PRE-COMPLETION SOUND INSULATION TESTING

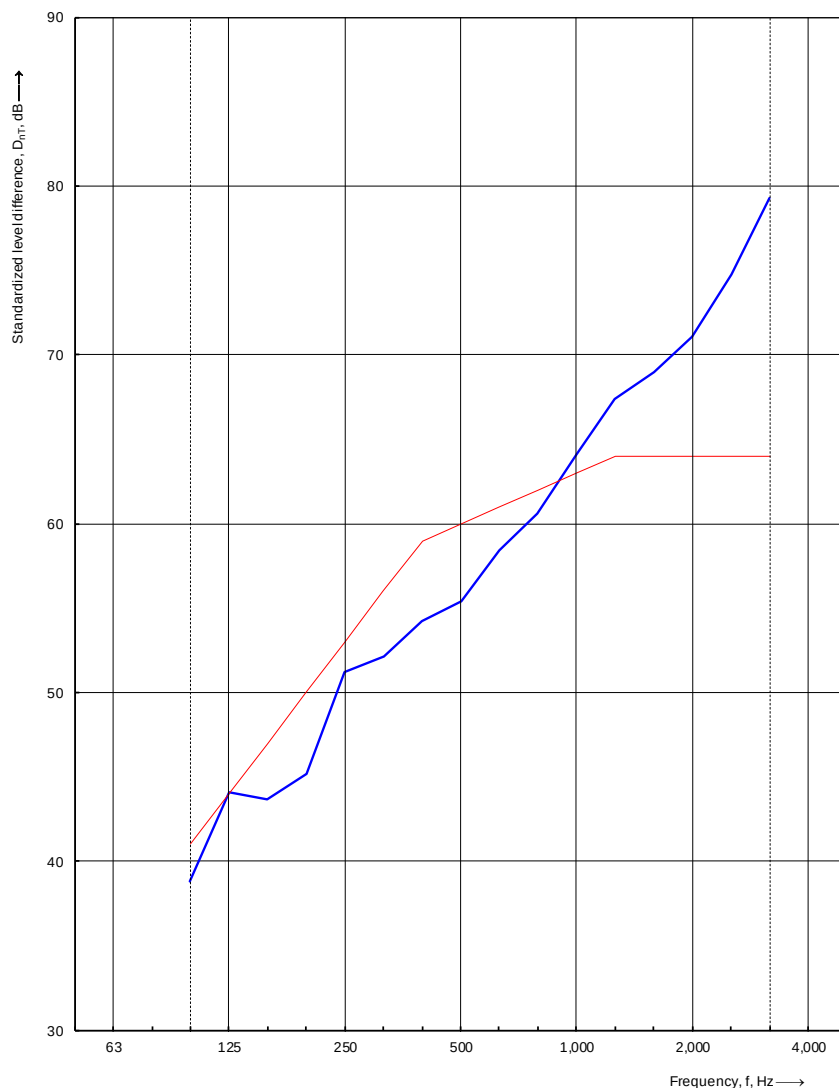
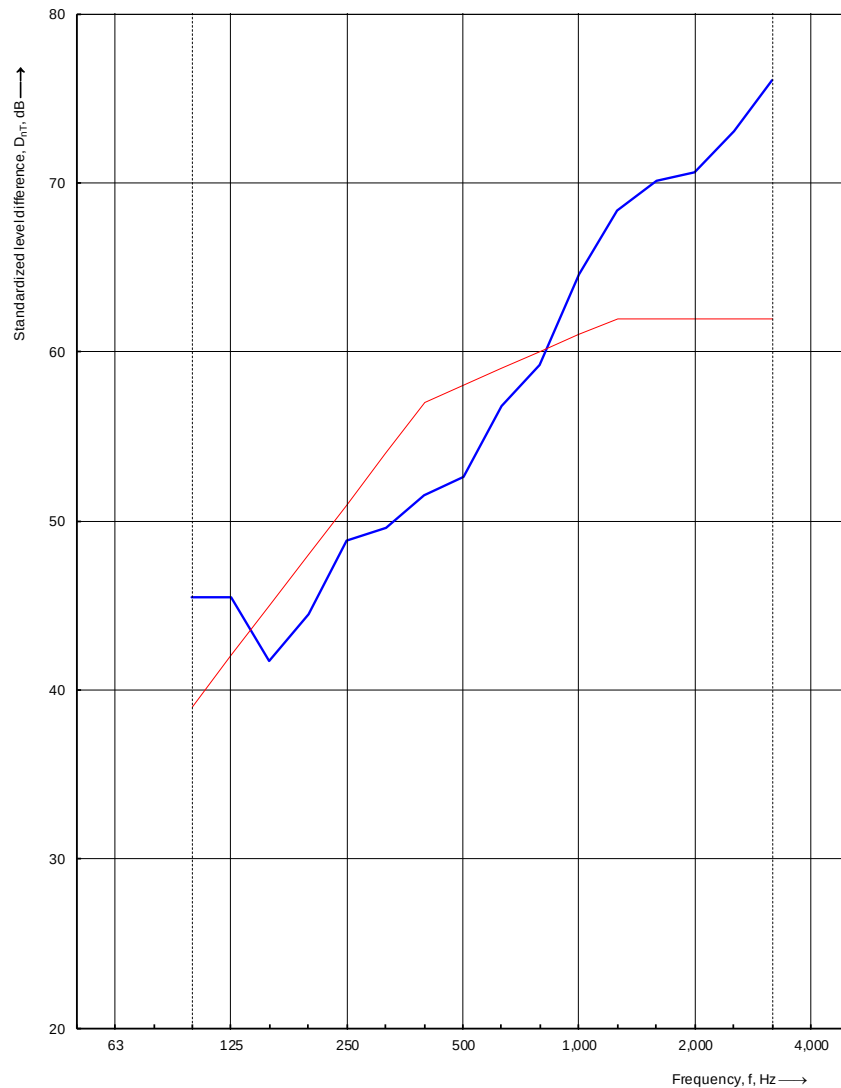
Thank you for forwarding Anderson Acoustics' Pre-completion Sound Insulation Testing report (ref.: 4757_001R_1-0_BP, dated June 2020) and associated photographs.

Having now reviewed this report, it is not possible at this stage to recommend that the relevant condition can be discharged. The report references Approved Document E which is a Building Regulation publication. Furthermore, it is my understanding that Approved Document E relates to residential properties and not buildings in commercial use.

As previously advised, this Department would expect that a suitably qualified, independent acoustician is employed to establish the location of the nearest noise sensitive receptor(s), calculate the likely sound levels (to include tonality, etc.) from the proposed use and ascertain whether this is likely to be problematic for the occupiers of the previously identified receptor(s). Based on this, an appropriate acoustic attenuation scheme can be designed. Once the local planning authority has approved the scheme, works can commence and once completed, a test shall

be undertaken to ensure the scheme is effective. The submission received to date does not adequately address these requirements.
